Our Ref: BE/92/21/DOC

Part 5 of the Town & Country Planning (Development Management Procedure) Order 2015
Approval of details reserved by condition imposed under ref. BE/135/18/PL relating to
Condition No. 15 (full permission) regarding the submission of As-Built Drawings and a
Completion Report prepared by an independent engineer

Land at Salt Box, West of Shripney Road, Bognor Regis

Arun District Council have decided to **REFUSE details reserved by this condition**

TYPICAL ARRANGEMENT OF PIPE JUNCTIONS WITHIN MANHOLES

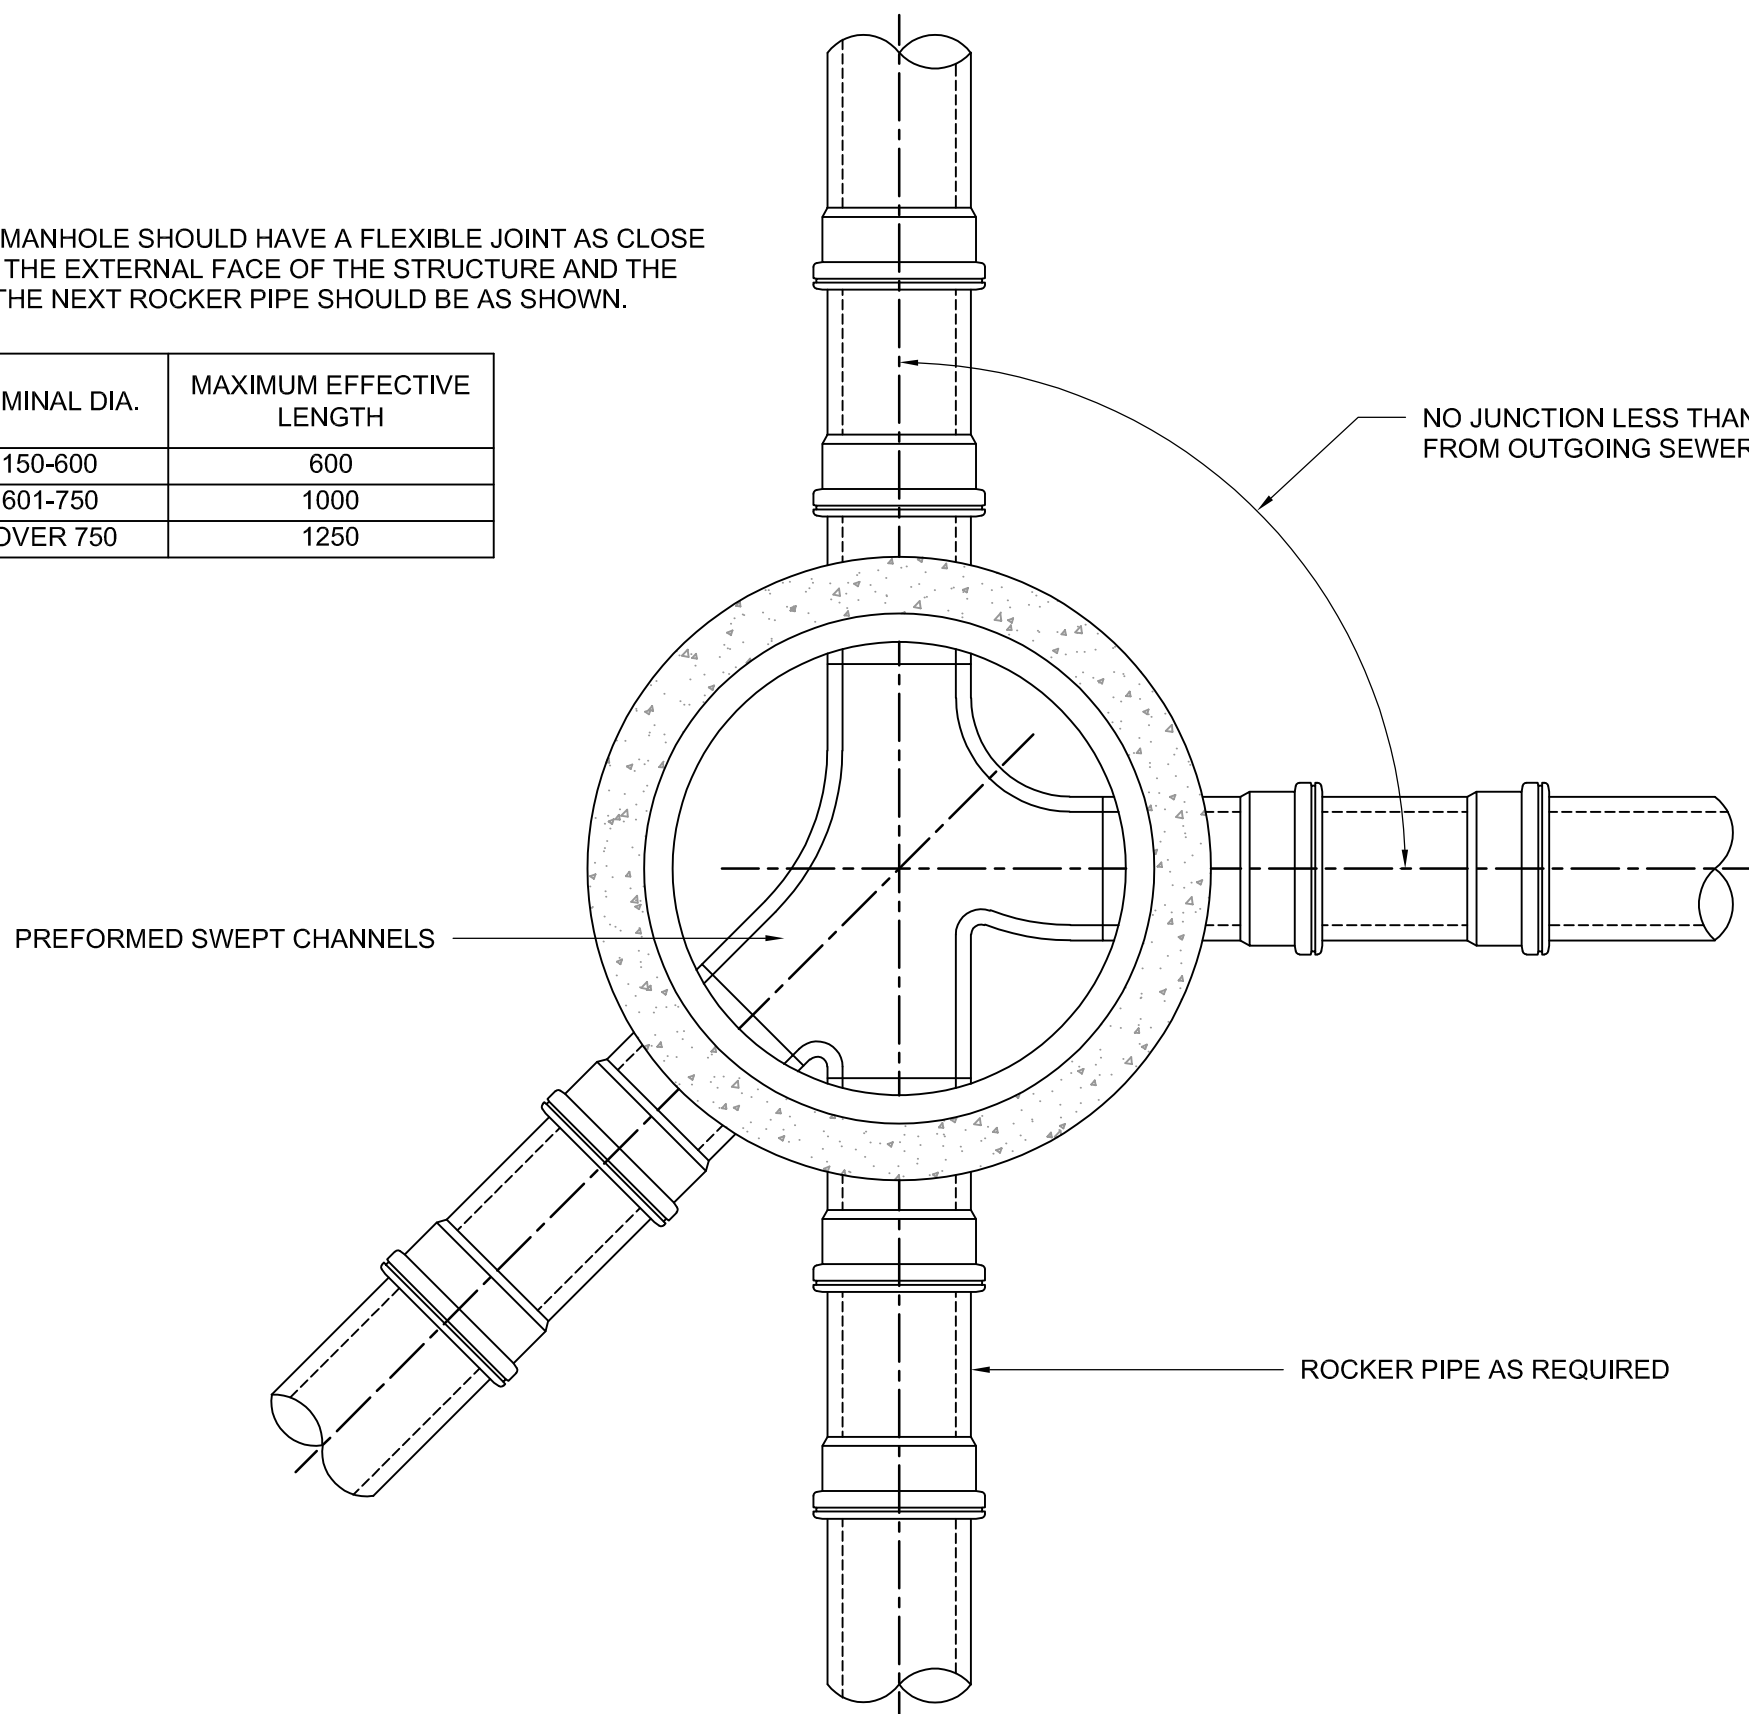
It is evident that substantial changes have been made to the drainage since the approval. A review of these changes has been completed. Levels at some manholes are considerably different between the approved design and as built drawings, the difference in levels is in excess of 50mm in some areas. It appears that at one location an outgoing invert is significantly above the incoming invert to the chamber, and in others downstream inverts are higher than the invert levels of upstream attenuation crates.

| DRAWING NO. (PROJECT CODE-ORIGINATOR-ZONE-LEVEL-TYPE-ROLE-NUMBER)<br>SAL-HYD-00-ZZ-DR-C-7110 |  | REVISION<br>C04    |

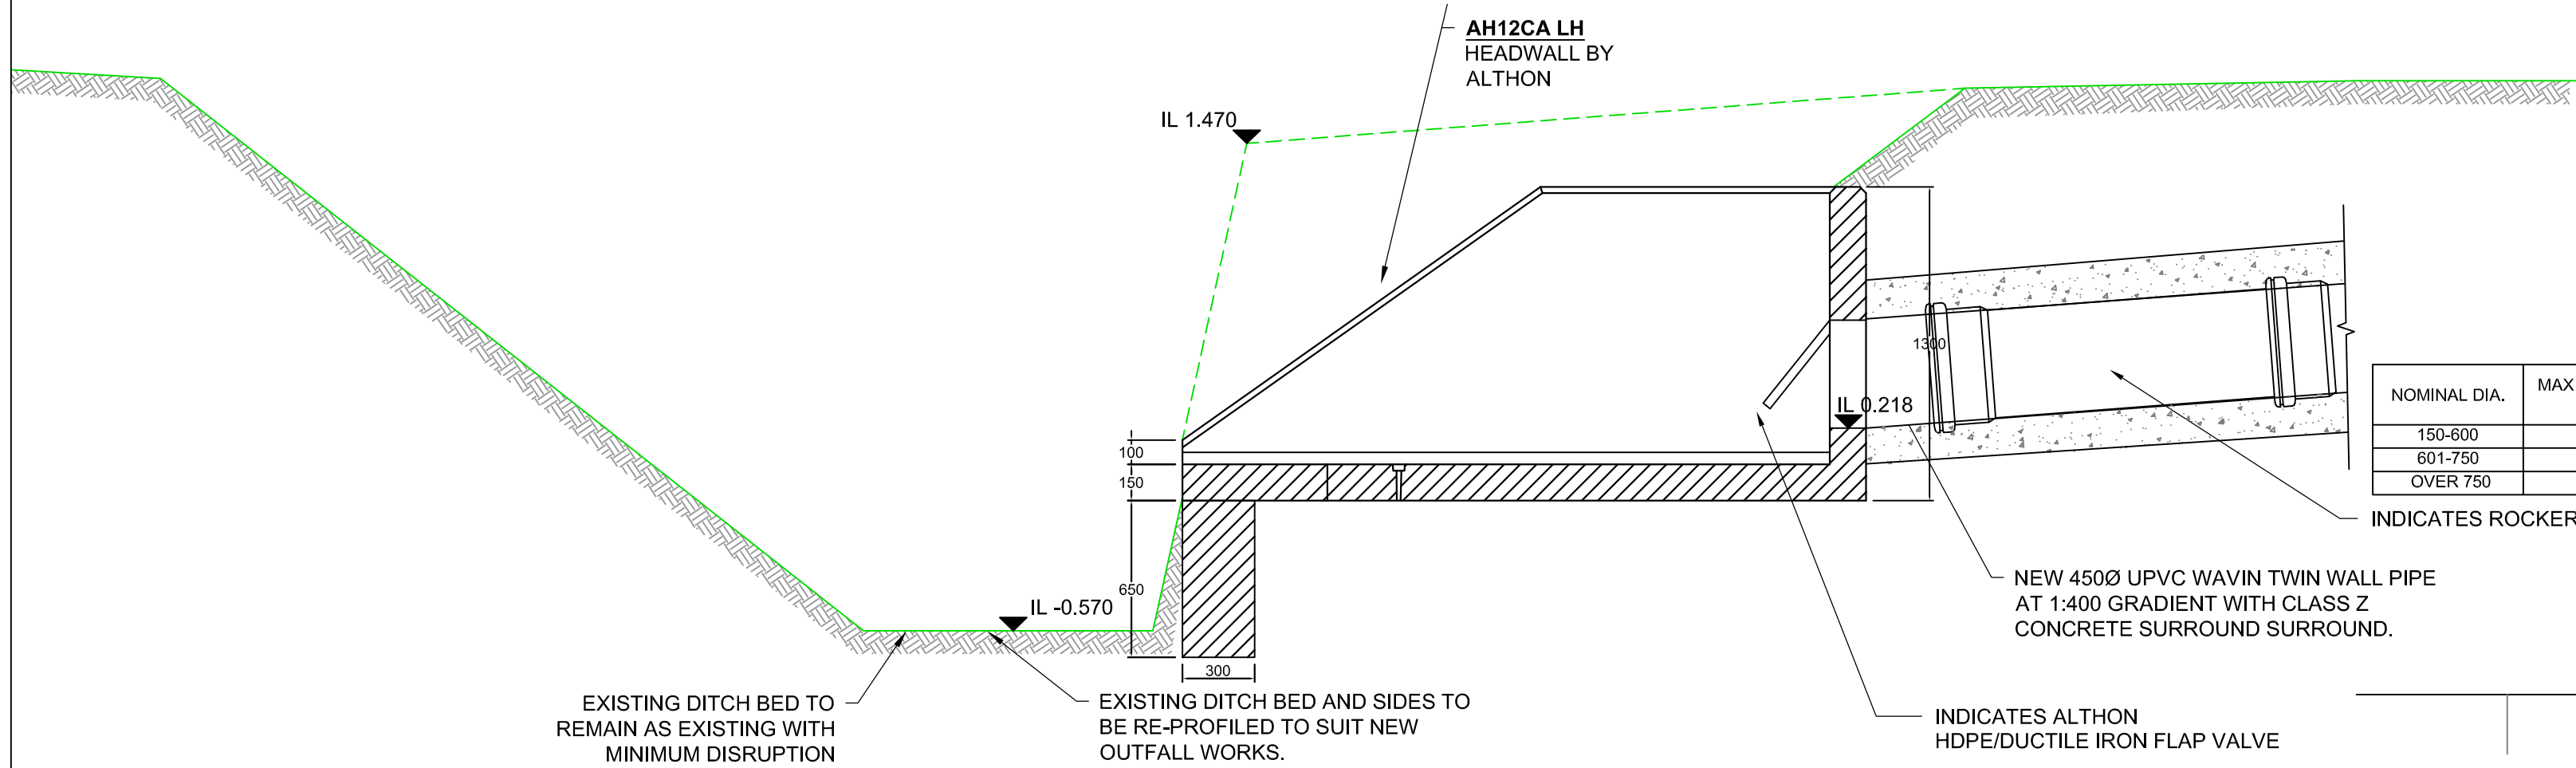
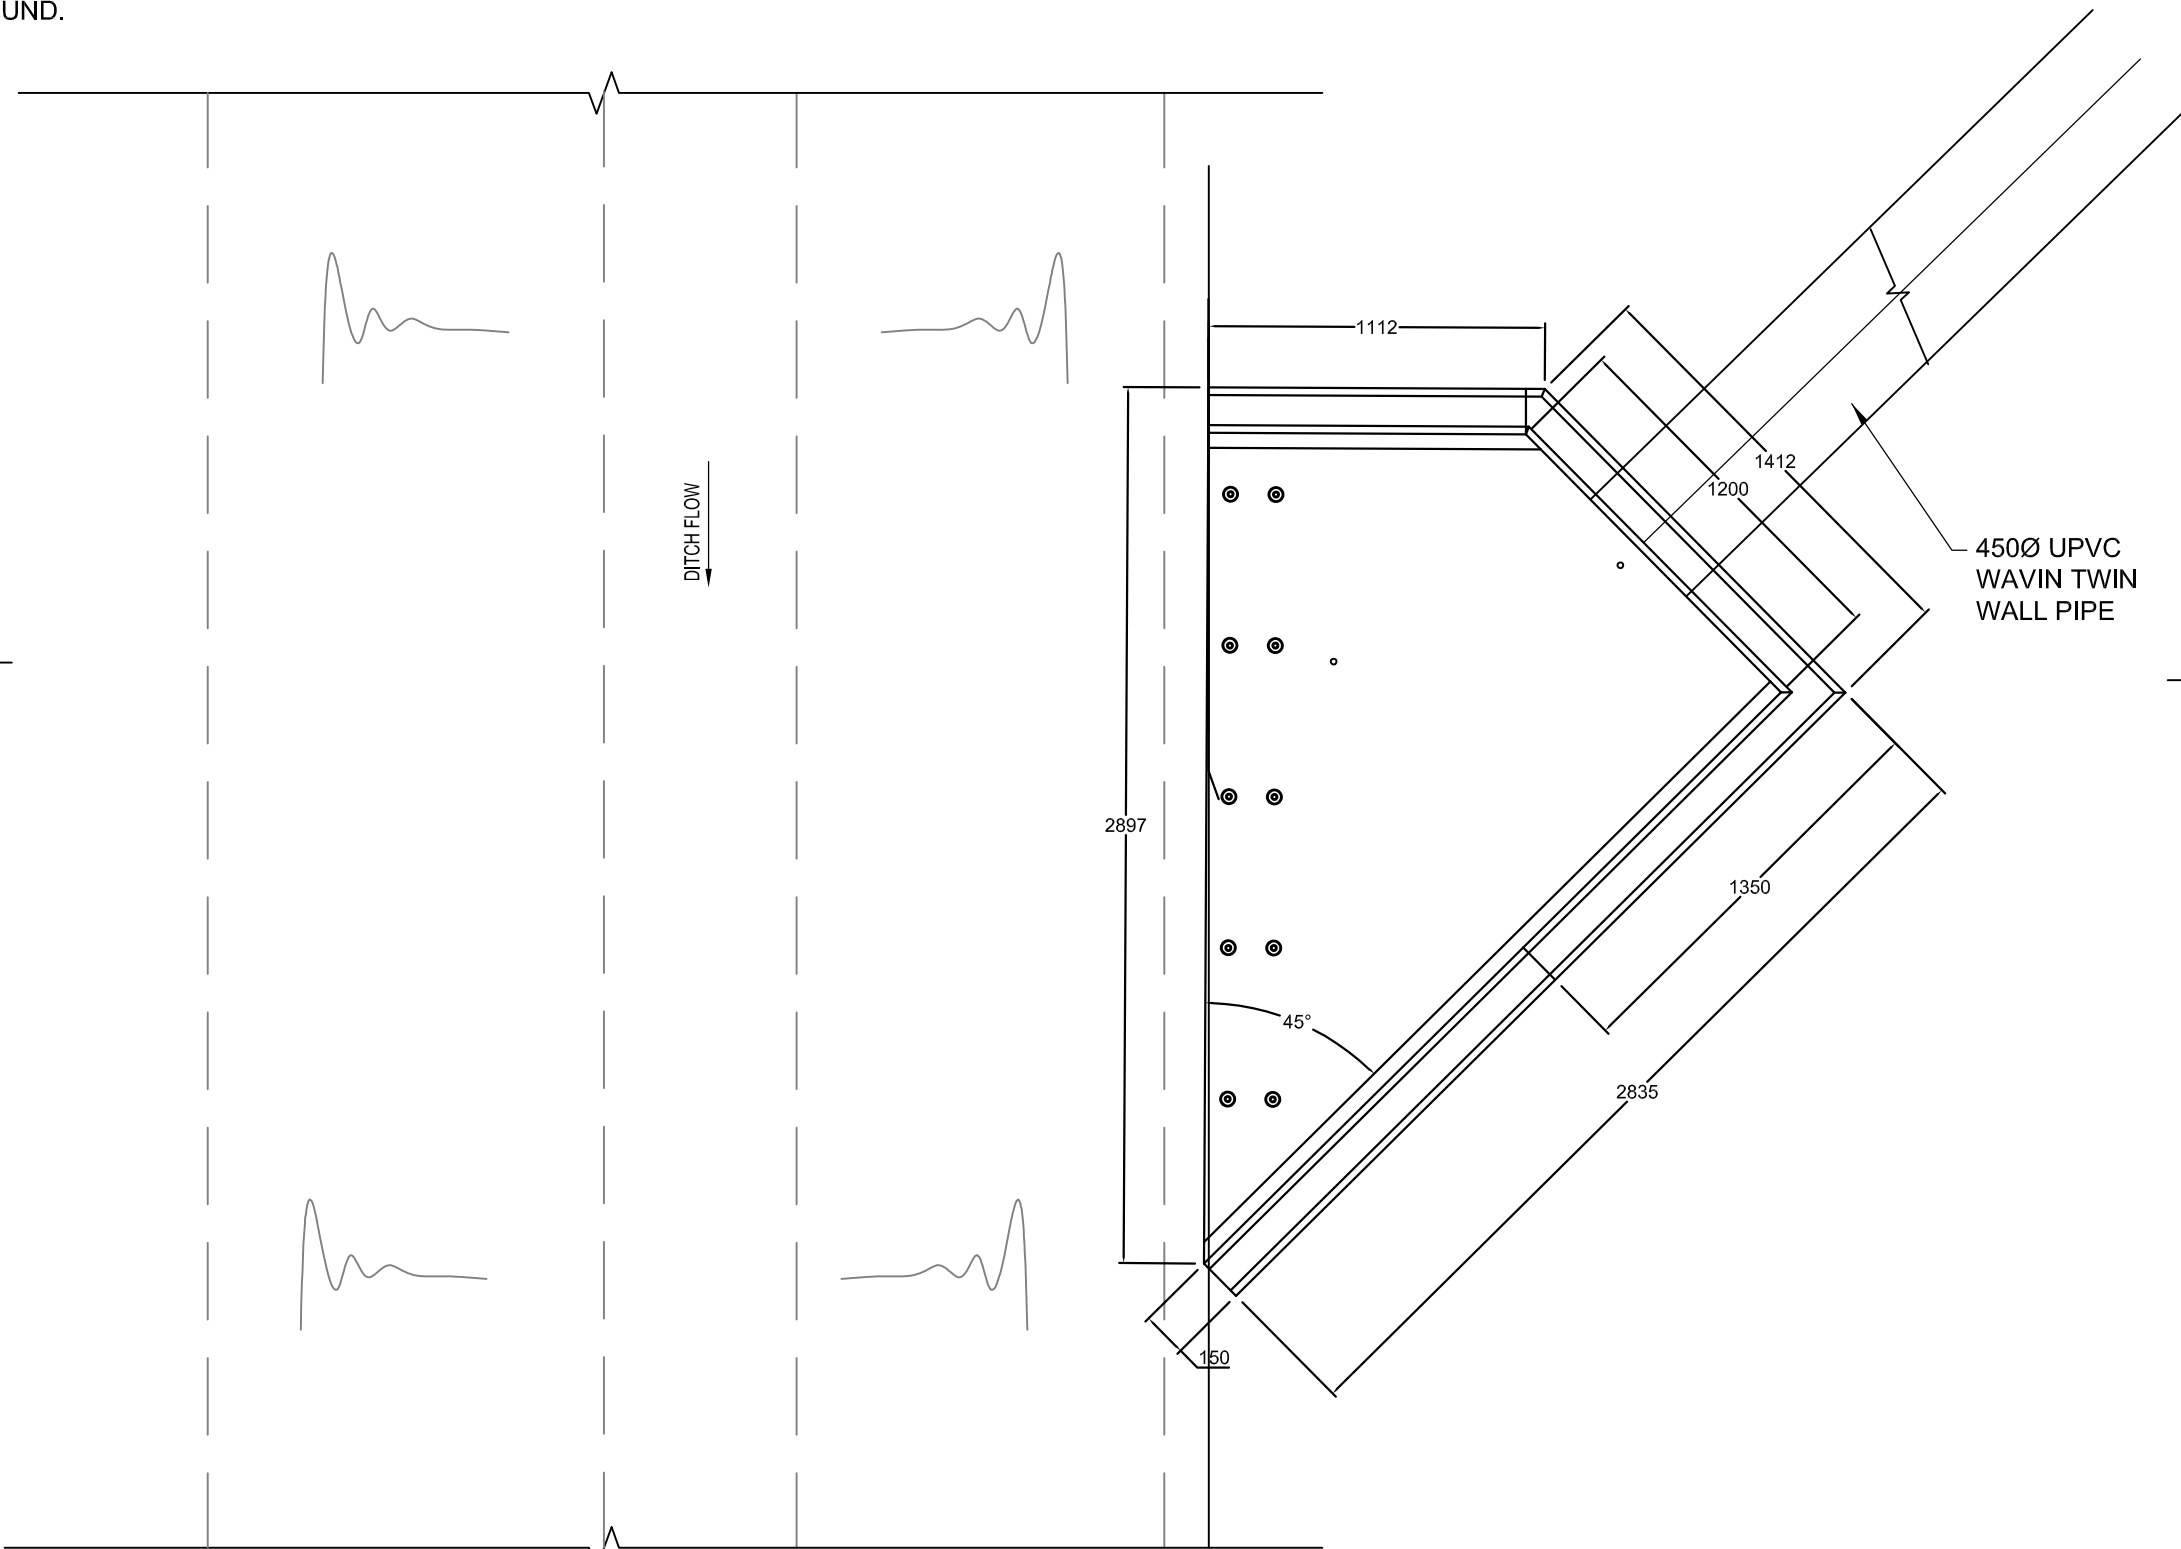
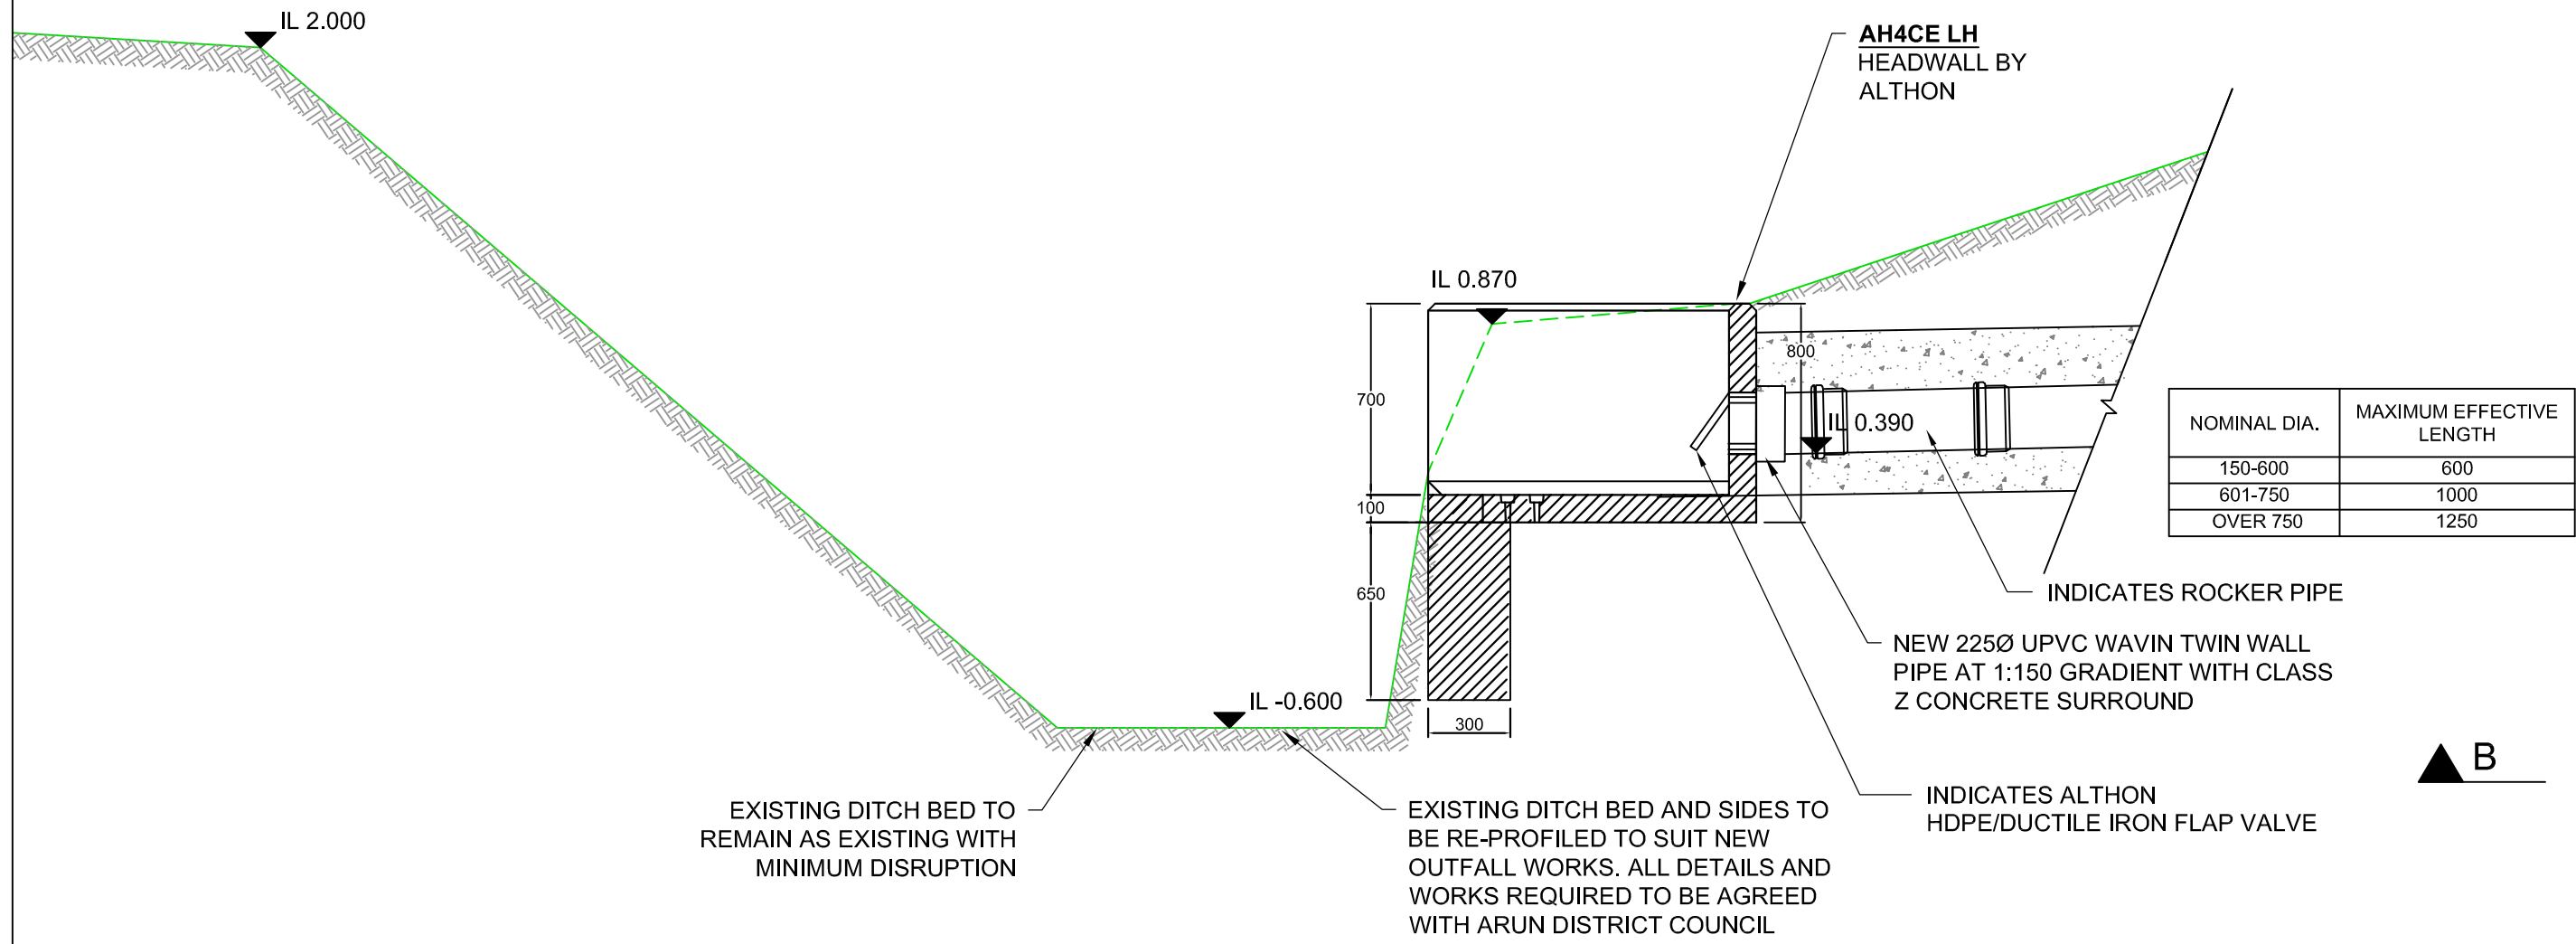
The headwall angles have been altered since approval. No evidence has been submitted to prove that the relevant consents (FRAP and Land Drainage Consent) apply to the revised headwalls.
